May 13, 2022

**Devtrin (Island Park) Inc.**  
c/o Trinity Development Group Inc.  
77 Bloor Street West, Suite 1601  
Toronto, ON M5S 1M2

Re: Roadway Traffic Noise Addendum Letter  
70 Richmond Road, Ottawa  
GW File No.: 20-143 – Noise Addendum Letter

LEVEL 8

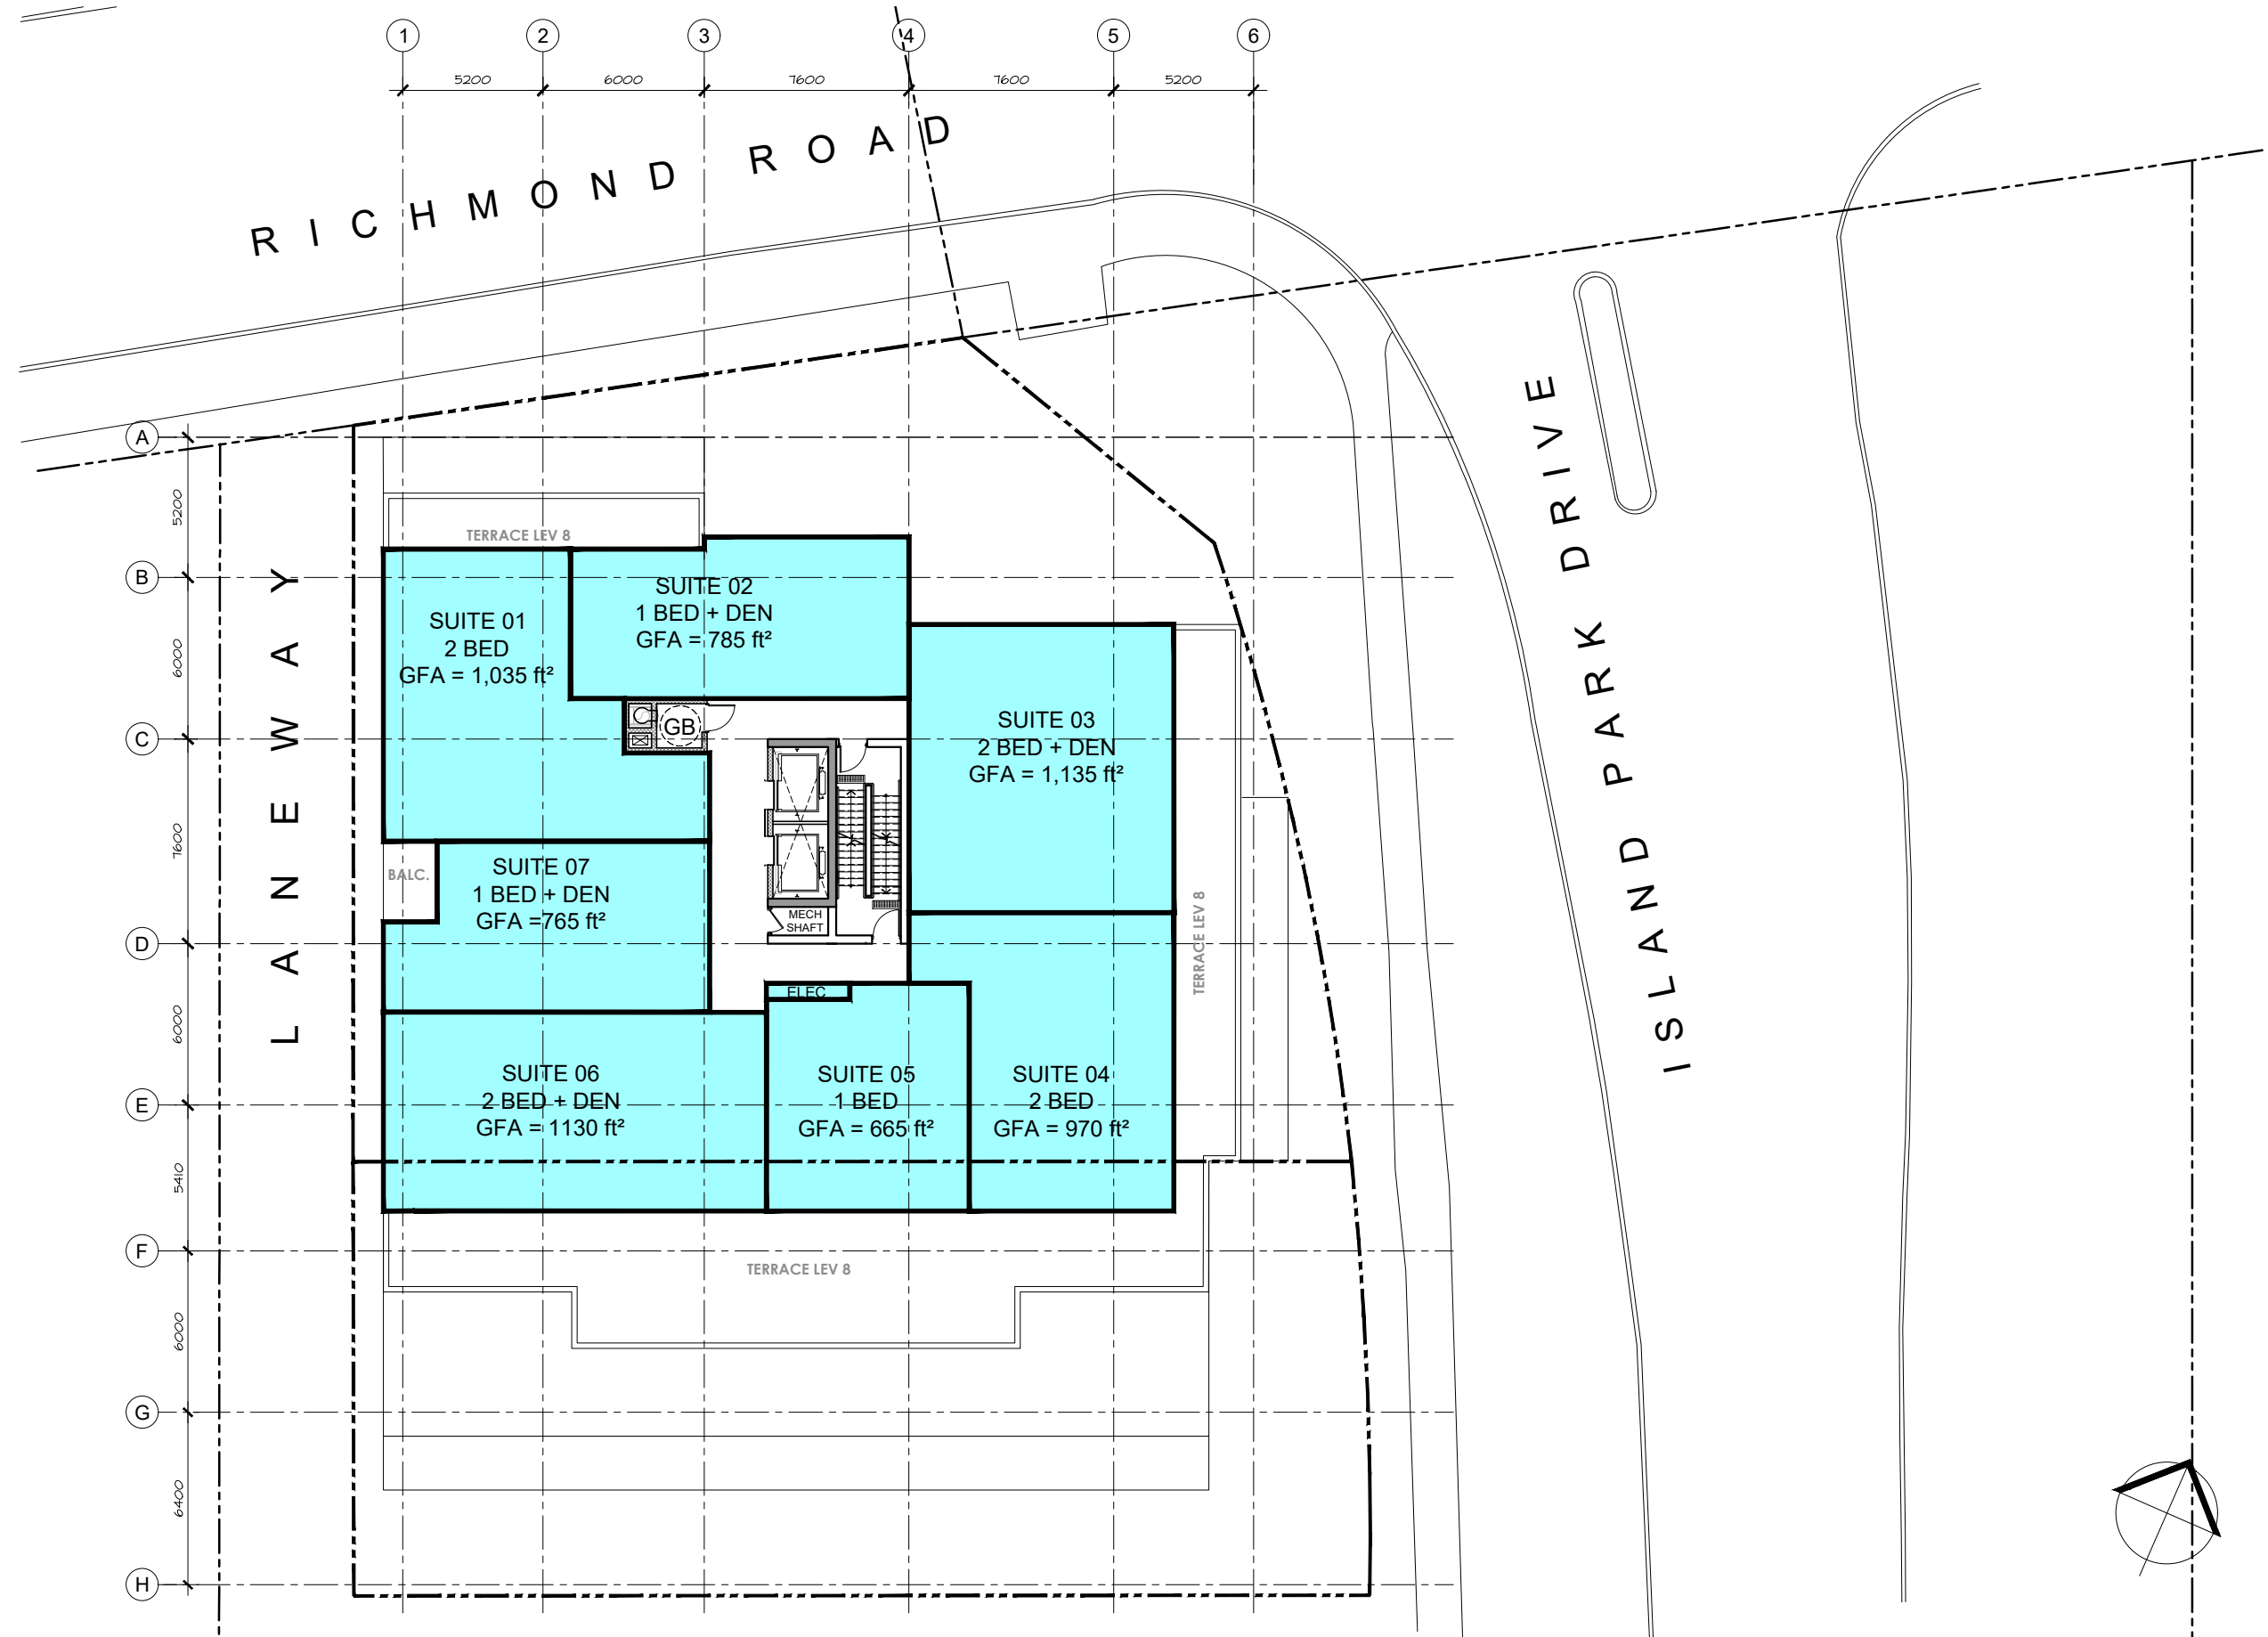
- Minor floorplate changes resulting in different terrace sizes, primarily at the Level 6, 8, and 9 terraces to the south.

similar mitigation measure used reduce noise levels at the Level 8 terrace, as summarized in Gradient Wind's noise report.

LEVEL 6

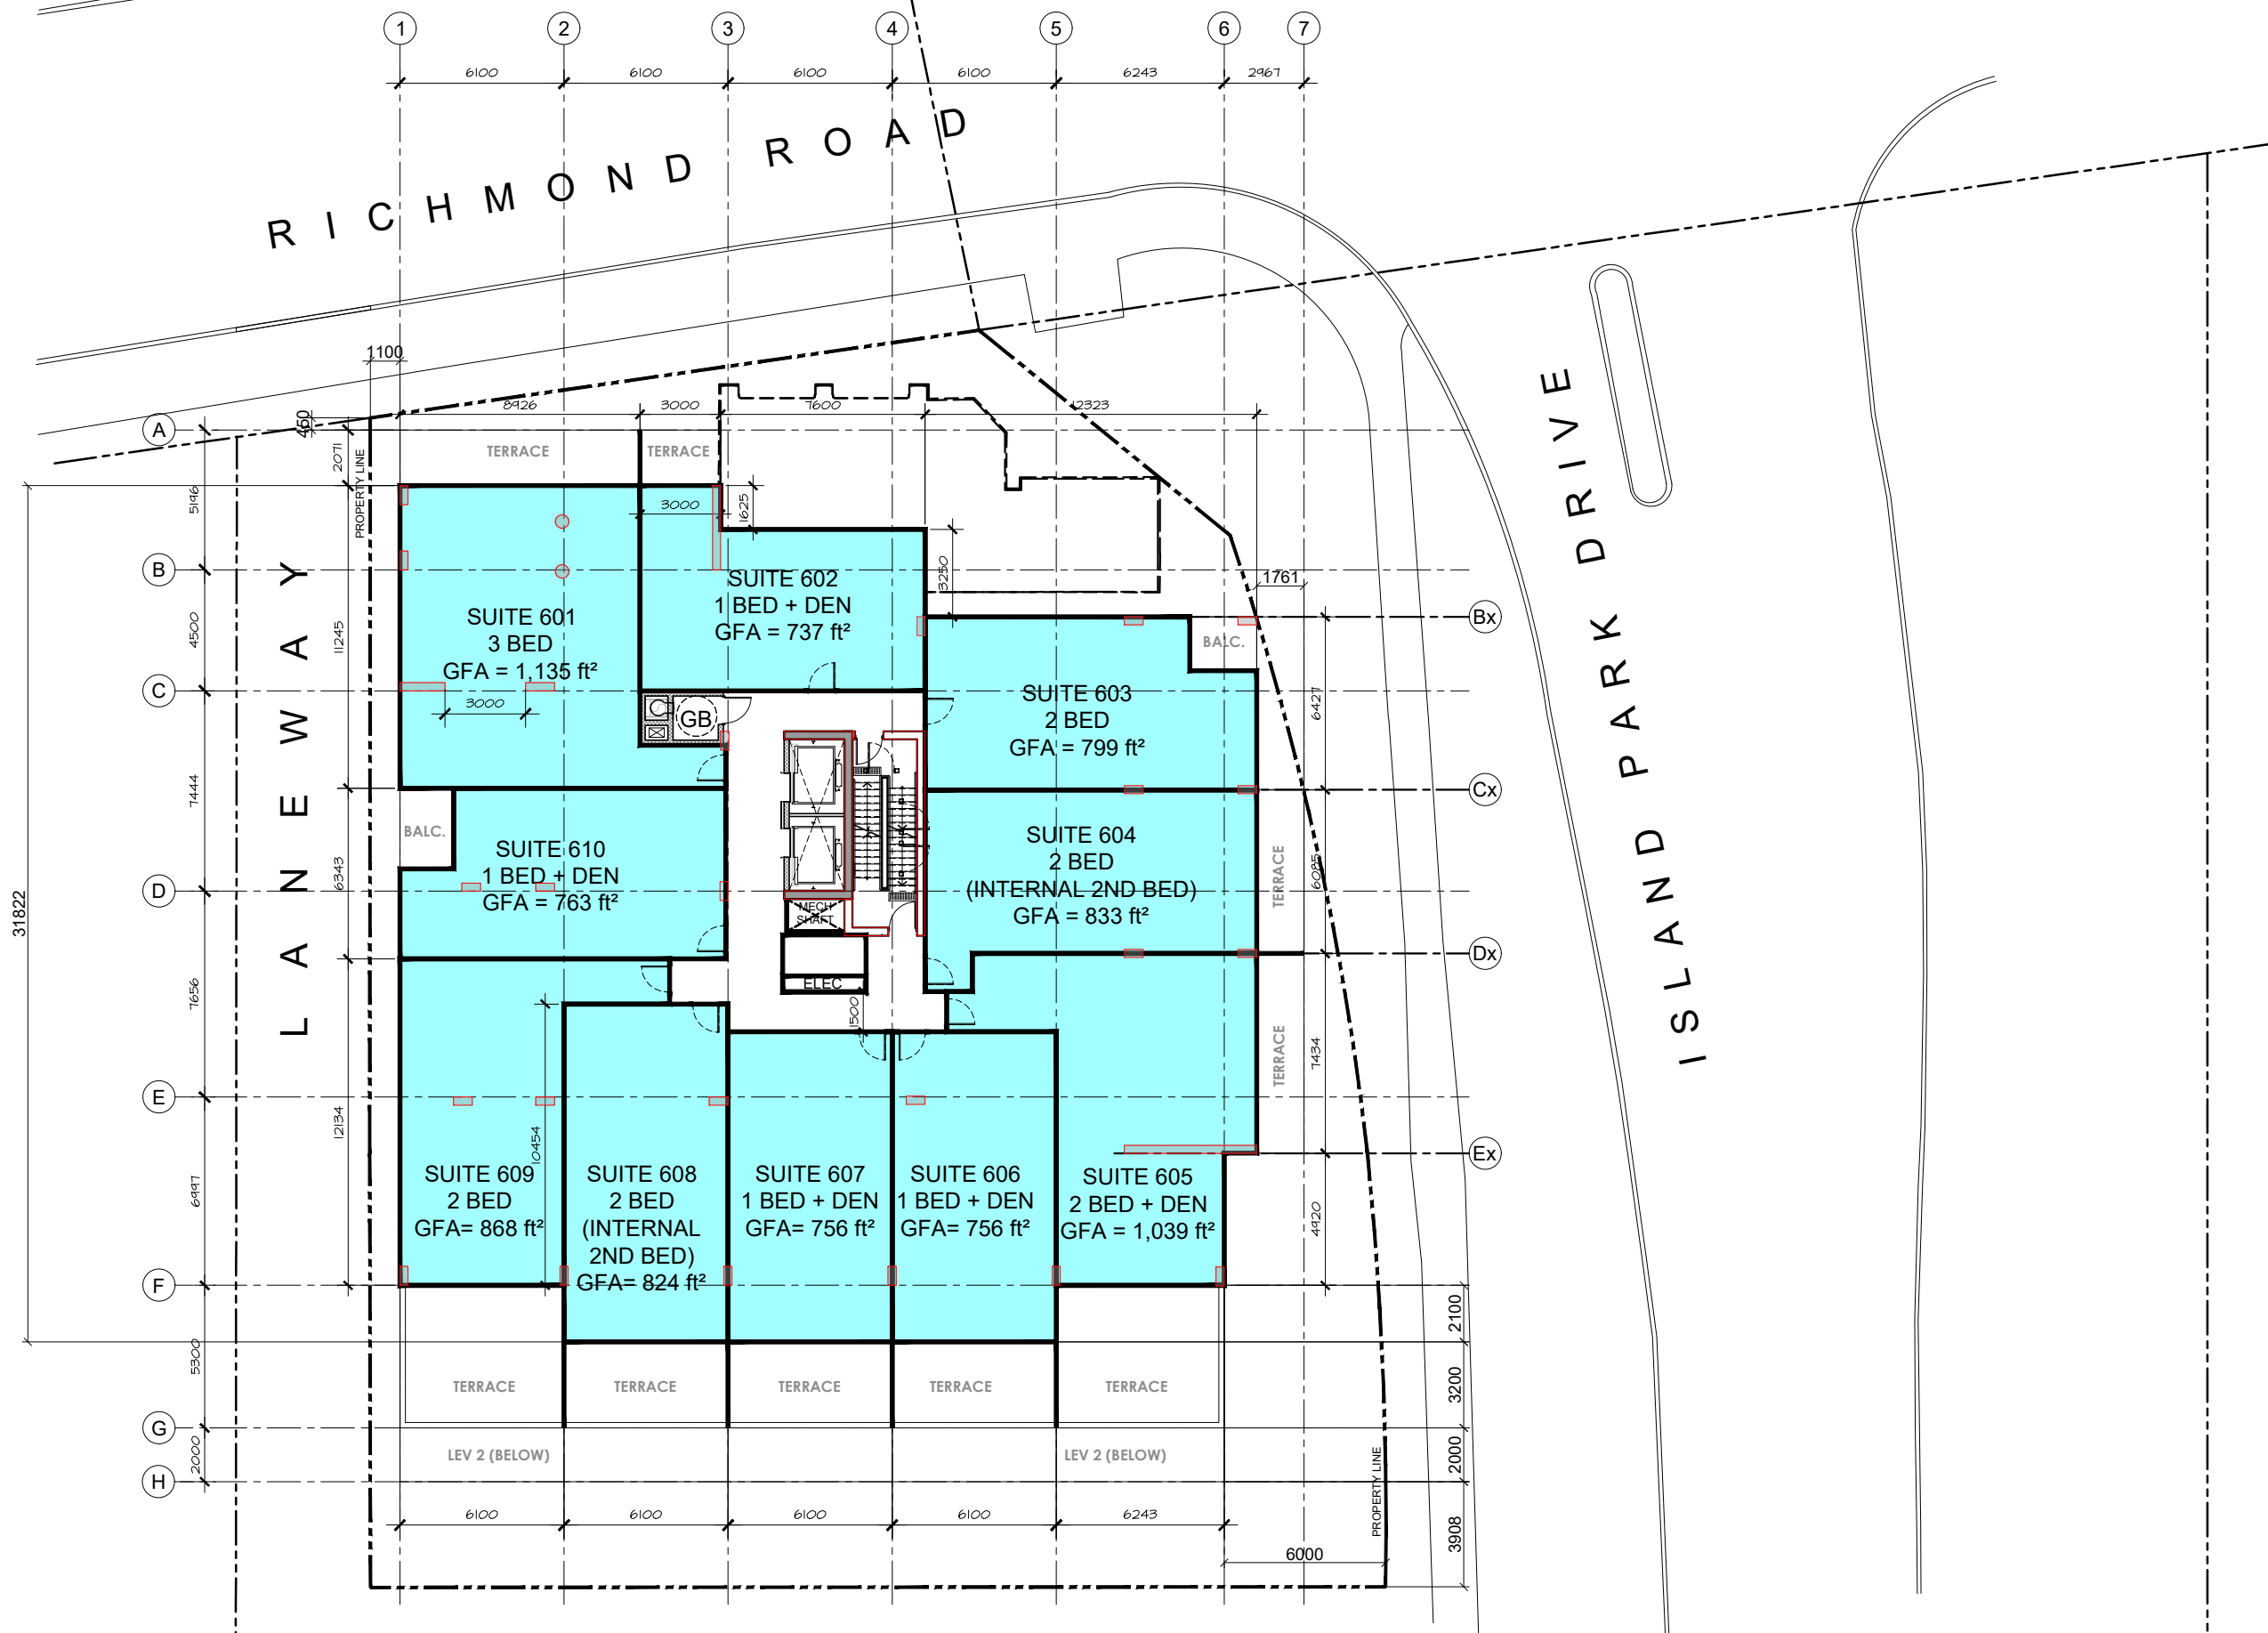
Given the changes noted above, noise levels at the facades of the building are not expected to differ from the values mentioned in Gradient Wind's noise assessment. Regarding the Level 6 terrace at the south elevation, the distance from the edge of the terrace to the building façade now exceeds 4m in depth. ENCG indicates that amenity areas greater than 4m in depth are considered noise sensitive. As such, a typical 1.1 m tall solid perimeter guard will suffice to reduce noise levels at or below 60 dBA. This is a

In conclusion, the drawings do not depict significant changes to the building design that would greatly alter the noise impacts onto the development from nearby transportation noise sources. As such, the initial recommendations and conclusions of our traffic noise report remain unchanged. The only addition is the inclusion of the Level 6 terrace perimeter guard requirements summarized in this letter.
